# Fassaroe Phase 1 Strategic Housing Development

Stage 1 Quality Audit

Cosgrave Property Group

April 2022

Figure 5-8 - Toucan Crossing across the N11 north bound off-slip

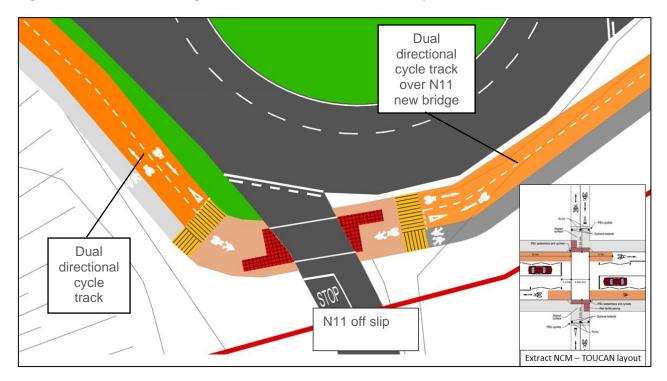
The proposed toucan crossing is in close proximity to the roundabout, where drivers are expected to yield for traffic on the roundabout (shown below in Figure 2-12). This may lead to drivers mistaking the green light at the toucan crossing as a green light to enter the roundabout. This may lead to the risk of road users entering the roundabout without yielding, which could result in side-impact collisions between vehicles.

Furthermore, a yielding vehicle (at the roundabout) may block the toucan crossing when stopped. In this case and when the toucan crossing is green for NMUs, their path may be blocked, which may cause them to enter the carriageway unsafely, and would be particularly problematic for wheelchair users or those with visual impairments.

Additionally, the Stop and two-way road markings on the slip lane are misleading to approach drivers, as the N11 slip lane is one-way.

The toucan crossing should be relocated to allow space for drivers to yield and to not impede the crossing while yielding. Only flashing amber or red signals should be used for the toucan crossing to avoid displaying a green signal to drivers. The Stop and two-way road markings should be removed and a yield marking provided before entering the roundabout.
